**ADC Planning Consultation
Conservation/Design Officer Response**

Application Number	BR/204/17/PL
Address	23 Station Road, Bognor Regis
Description	Replacement shop-front to a building on the edge of a designated area
Case Officer	Simon Davis
Date	27 September 2017

Section - Scale 1:10

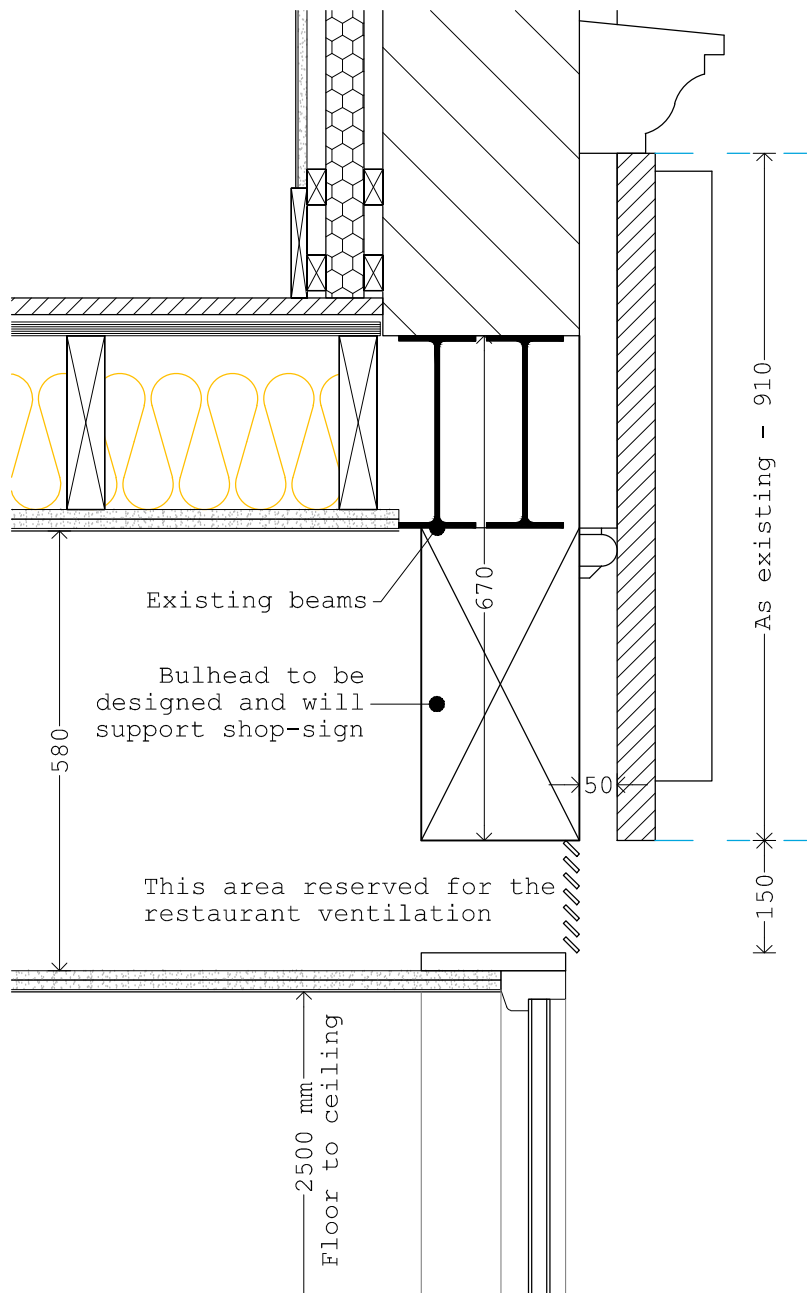
The proposed shopfront and signage are similar to those adjacent and they sit comfortably in the local context. Provided the new elements are of much the same appearance as those existing previously - and streetscene character remains unchanged in consequence - there is no objection in terms of the Policies referenced below.

However, while details of the new shopfront have been provided, no details of the shopfront as previously existing have been submitted. Due to lack of adequate supporting documentation, it is not possible to establish whether the new shopfront is a comparable replacement, and a conclusive recommendation cannot be made in terms of Local Plan 2003 Policy Area 2 and Local Plan 2014 Policy HER DM3.
